# Rezoning Transportation Analysis

Petition Number: 2023-172

## Revision Log:

Date	Description
01-23-24	First Review (IW)

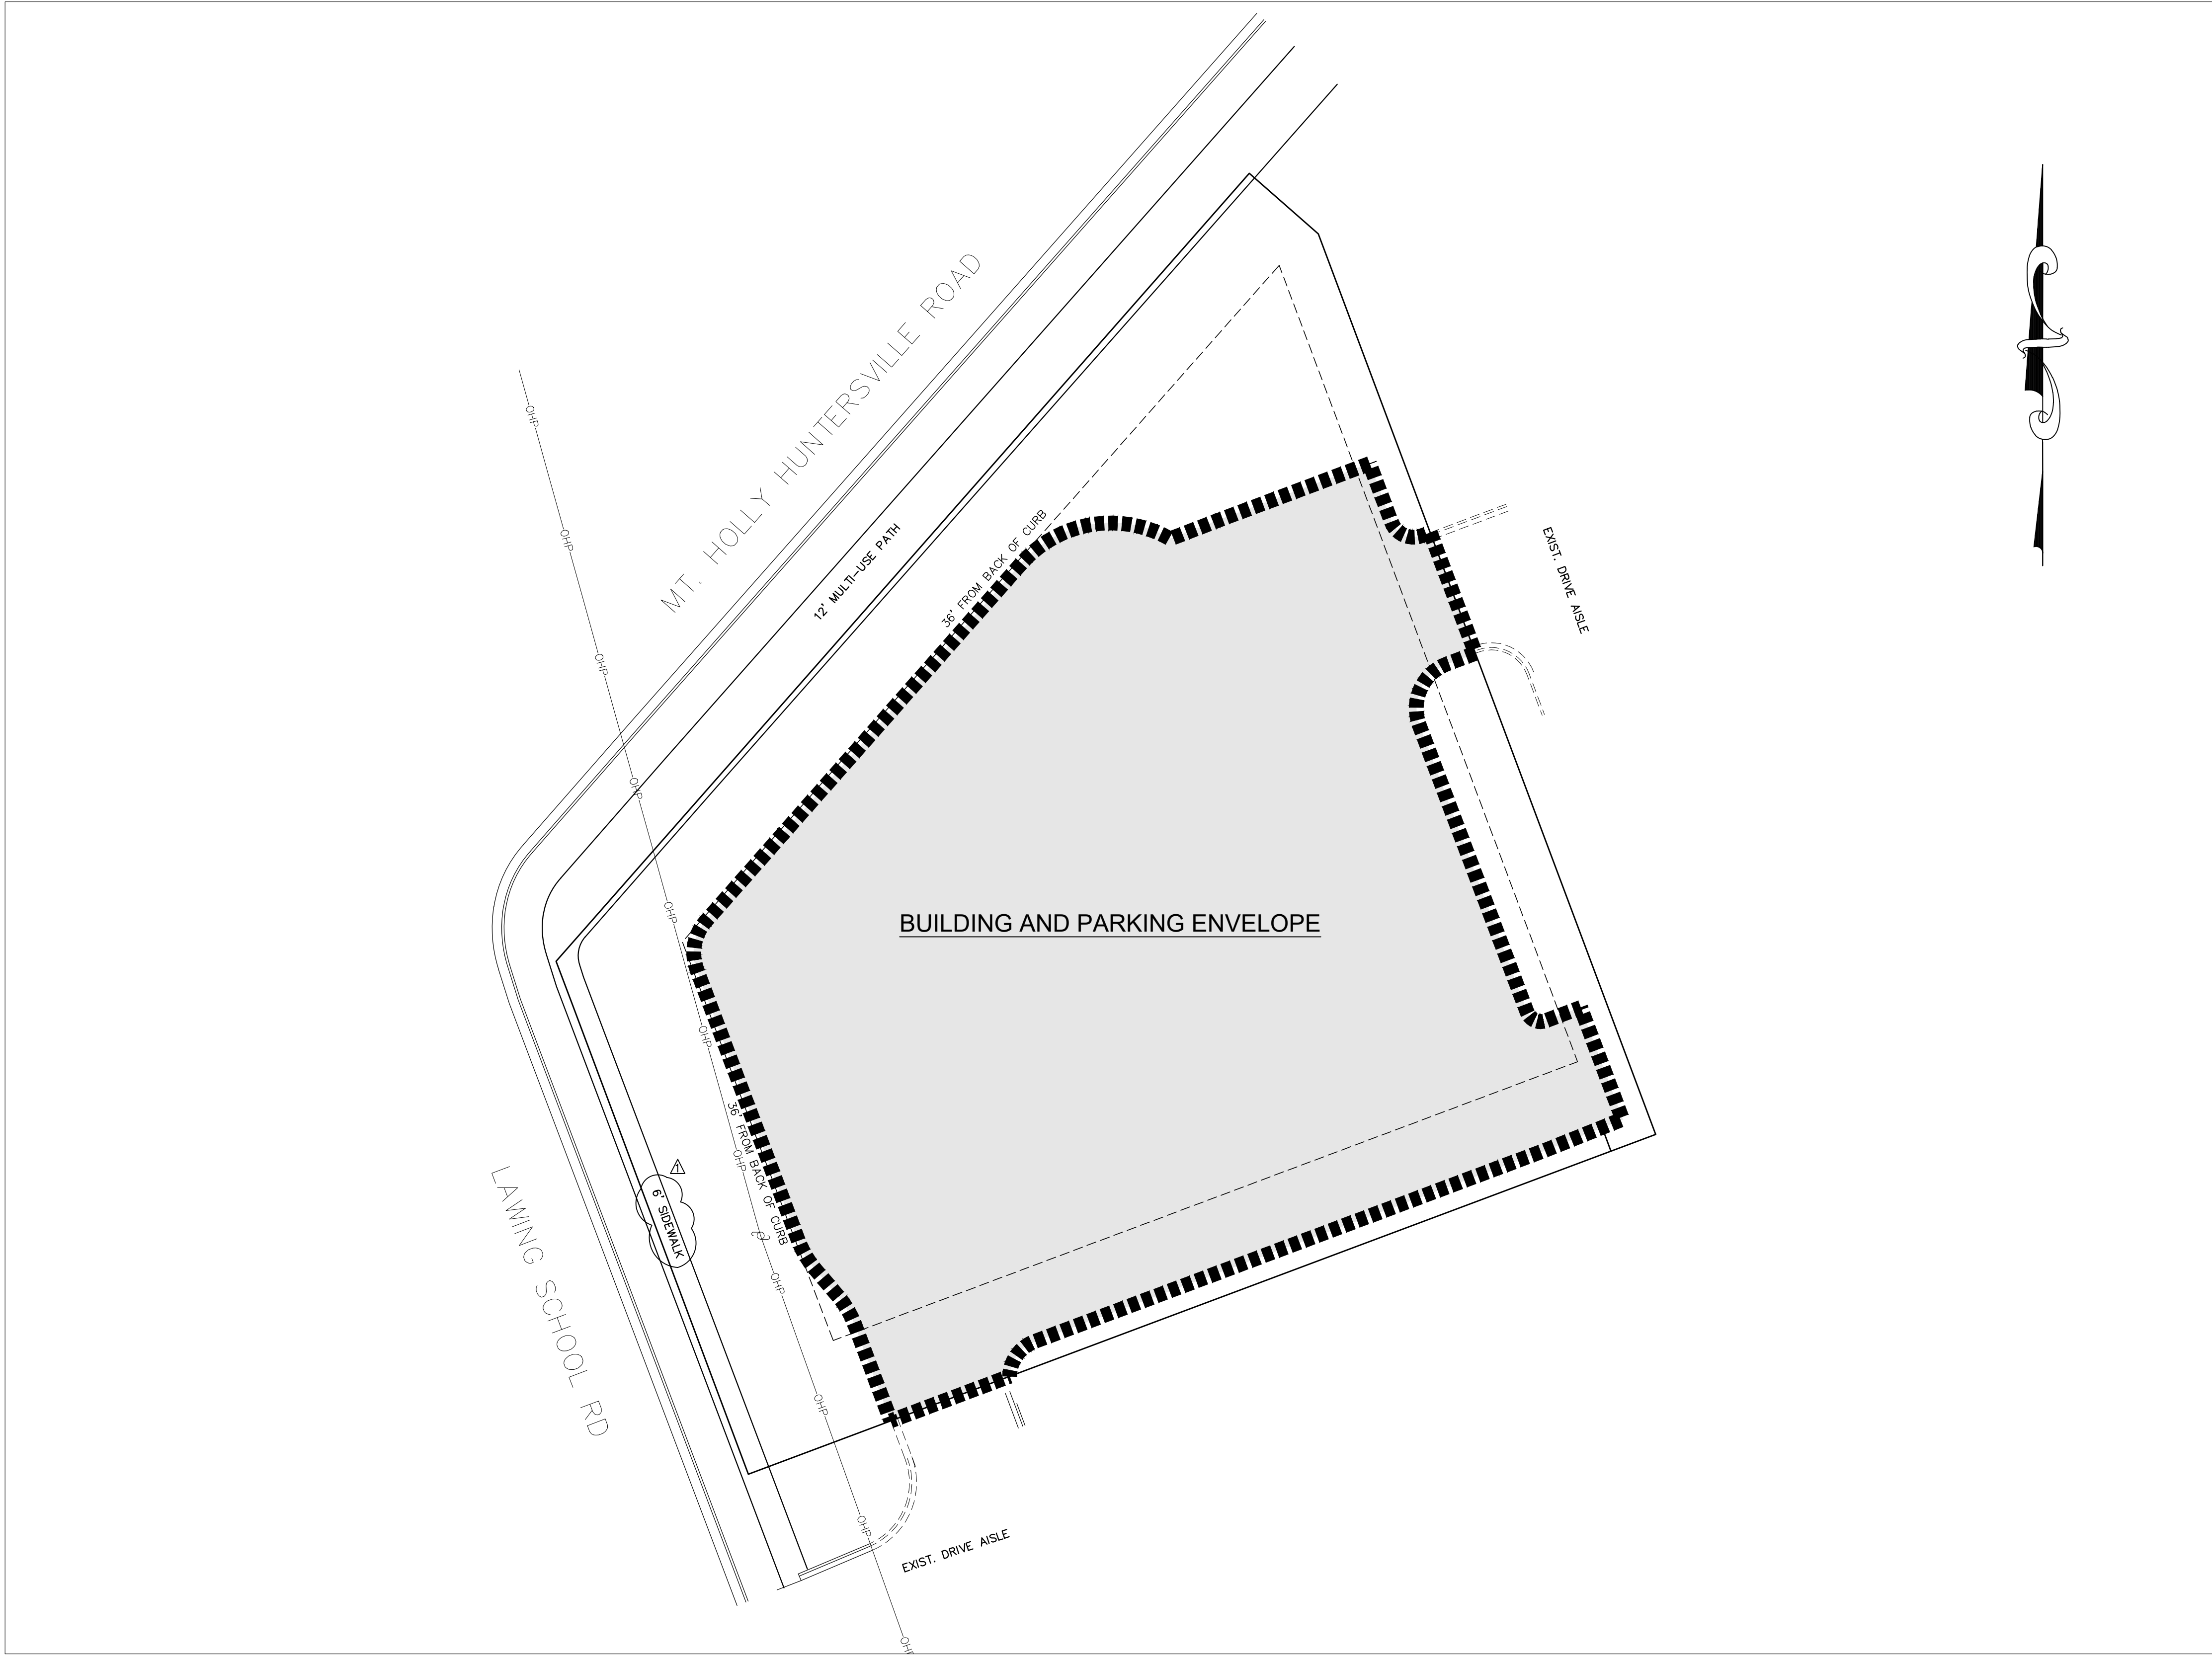
3. Revise site plan and conditional note(s) to commit to dedicate 50 feet of right-of-way from the Mt. Holly Huntersville road centerline. The site plan shall label and dimension the right-of-way from the road centerline.

4. Revise site plan and conditional note(s) to commit to dedicate 33.5 feet of right-of-way from the Lawing School road centerline. The site plan shall label and dimension the right-of-way from the road centerline.

6. Revise site plan and conditional note(s) to commit to cross-access at south eastern portion of site along Lawing School Road to align with Article 31 in the UDO. It appears the site may be committing by layout on site plan. CDOT would like to see labeling and/or language stating this will specifically be set up for cross access.

7. Revise site plan and conditional note 5.c. to specify which sidewalk the site is committing to constructing. The site plan shows a 12' MUP but the note references the Local Collector Street, which is actually CLDSM U-07B not a local narrow street. The sidewalk would be required to be 8'. Please update and specify which sidewalk width the site plan will be committing to.

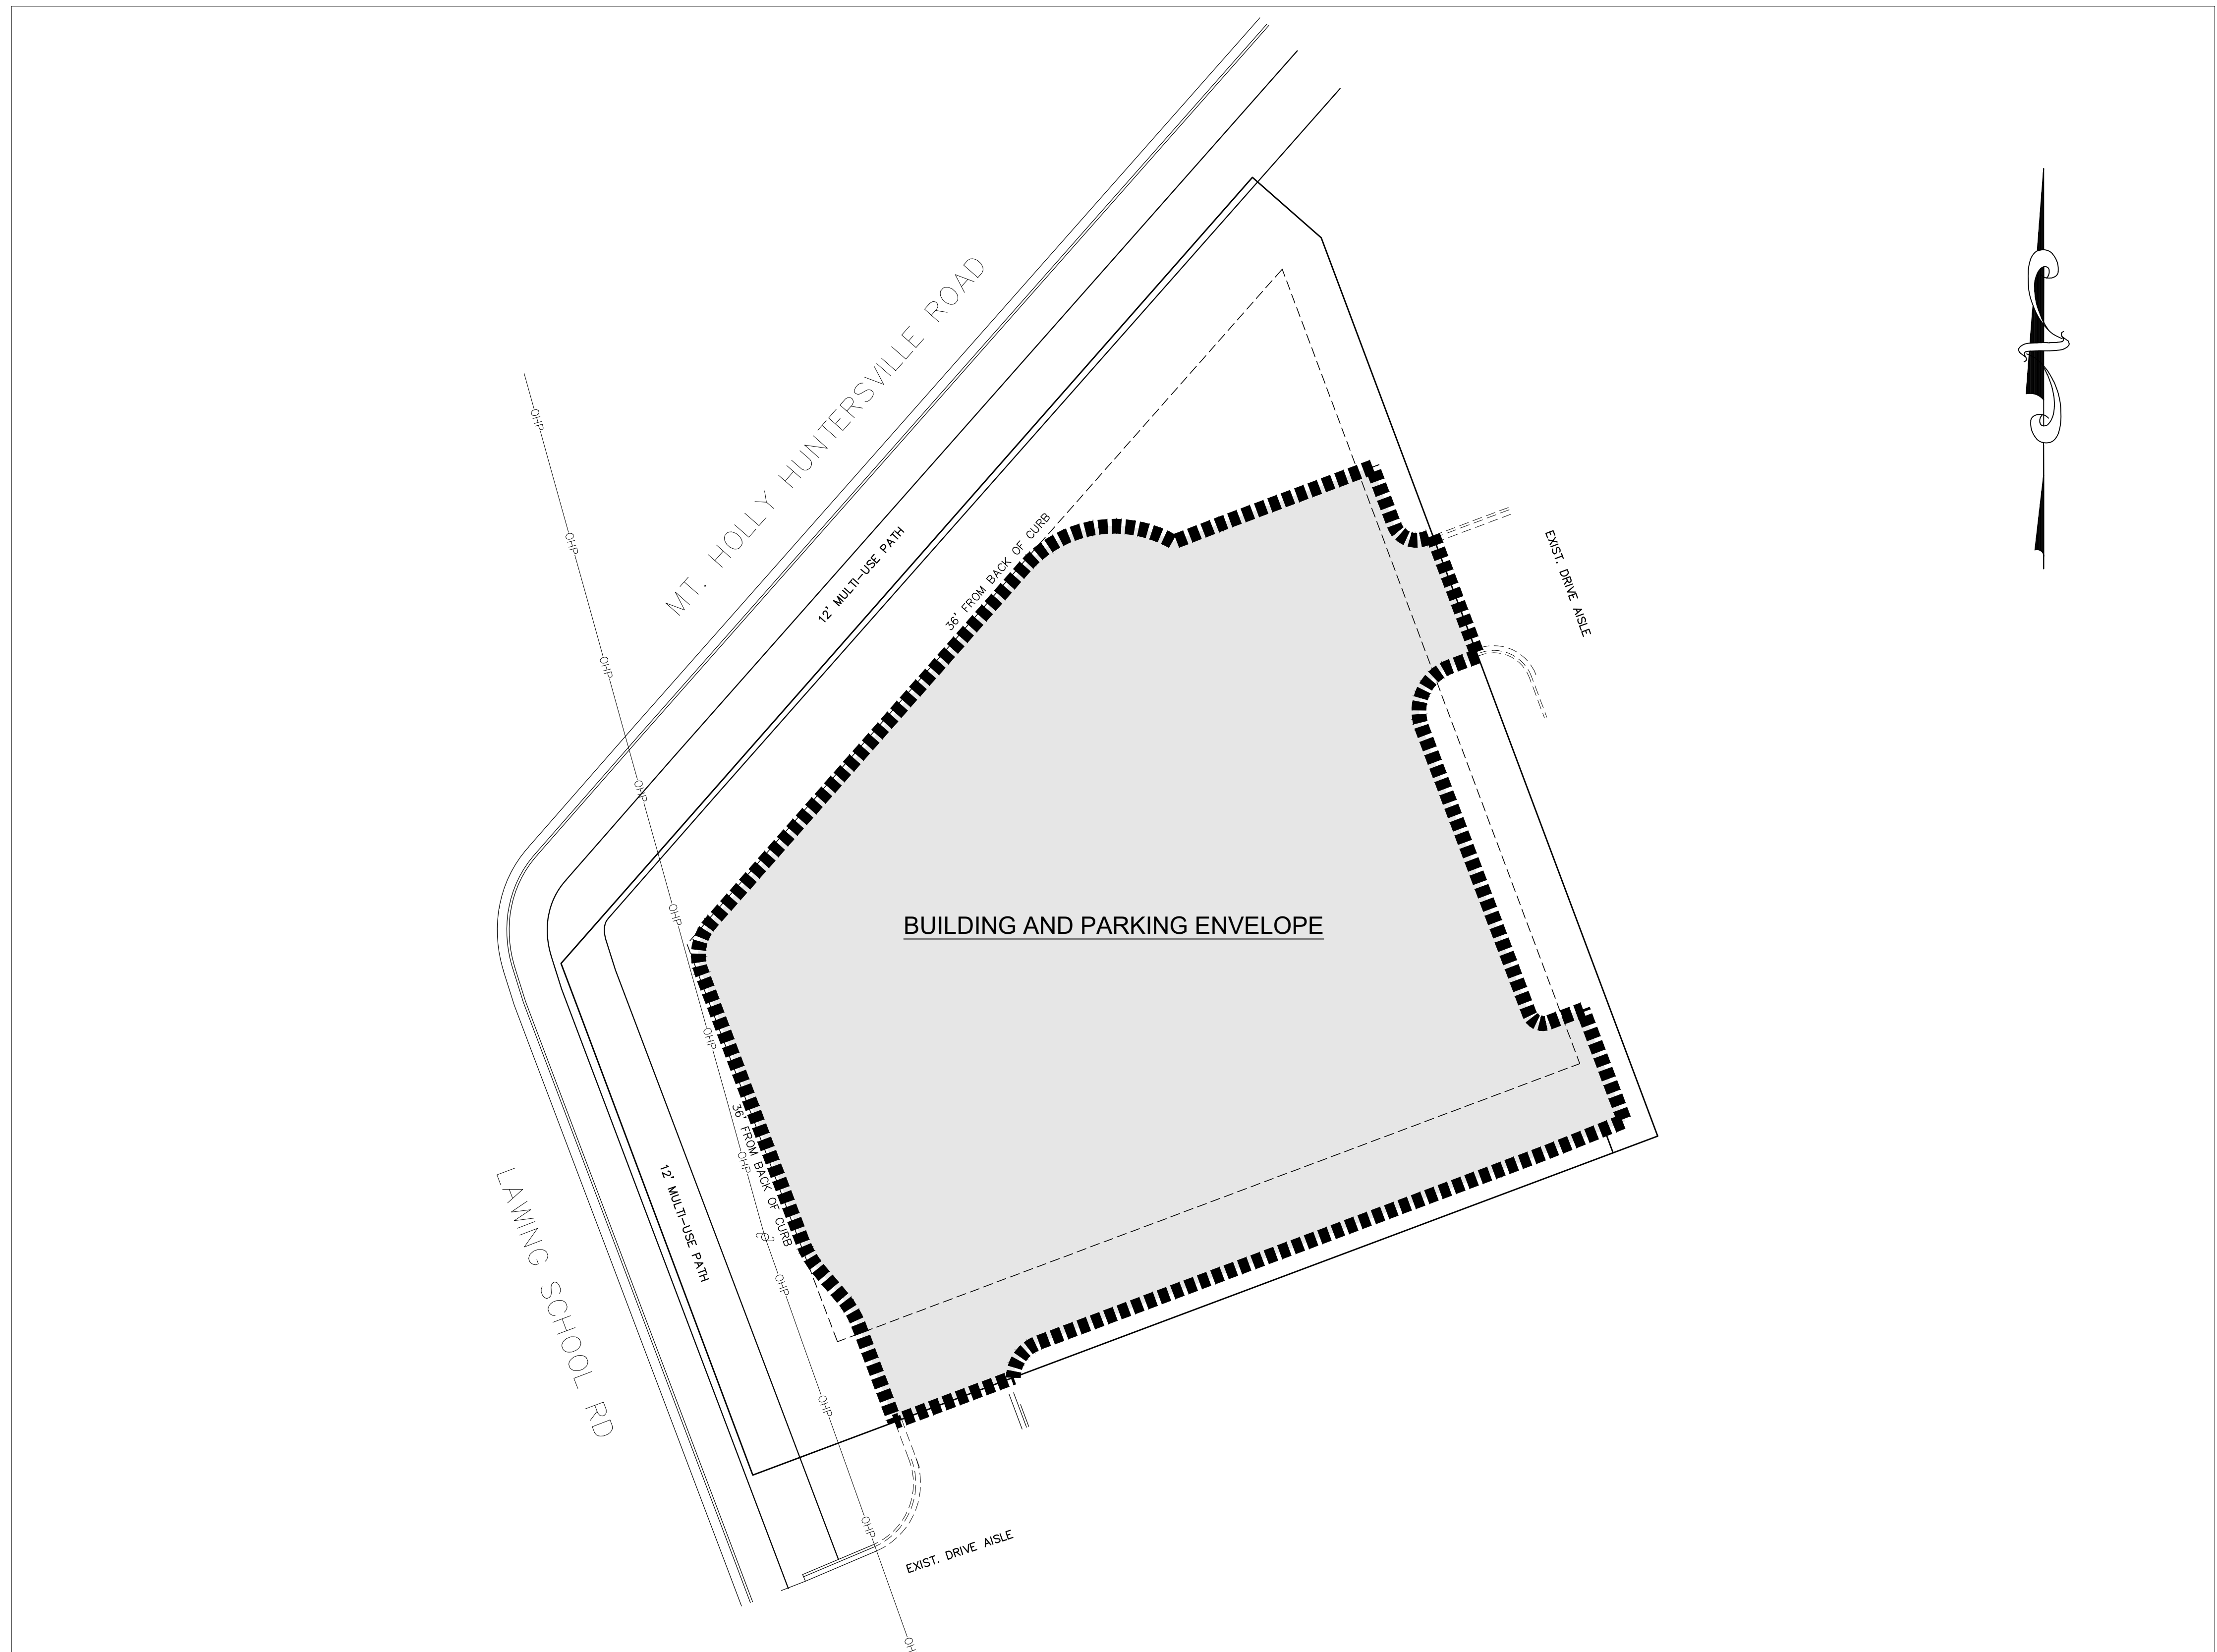
**1. Curblines:**

- a. **Mt Holly Huntersville Road:** The future location of curb and gutter is 30' from centerline and appears to be in its existing location.

- b. **Lawing School Road (Spell it out):** The future location of curb and gutter is in its existing location.

Label and dimension the curb and gutter from the centerline for each road on the site plan.

8. Add a conditional note specifying “the Petitioner shall dedicate and convey in fee simple all rights-of-way to the City before the site’s first building certificate of occupancy is issued. CDOT requests rights-of-way set at 2’ behind back of sidewalk where feasible.”

10. Add conditional note specifying “All public roadway improvements will be subject to the standards and criteria of CDOT and NCDOT, as applicable, to the roadway improvements within their respective road system authority. It is understood that such improvements may be undertaken by the Petitioner on its own or in conjunction with other development or roadway projects taking place within the broad north western Mecklenburg area, by way of a private/public partnership effort or other public sector project support.”
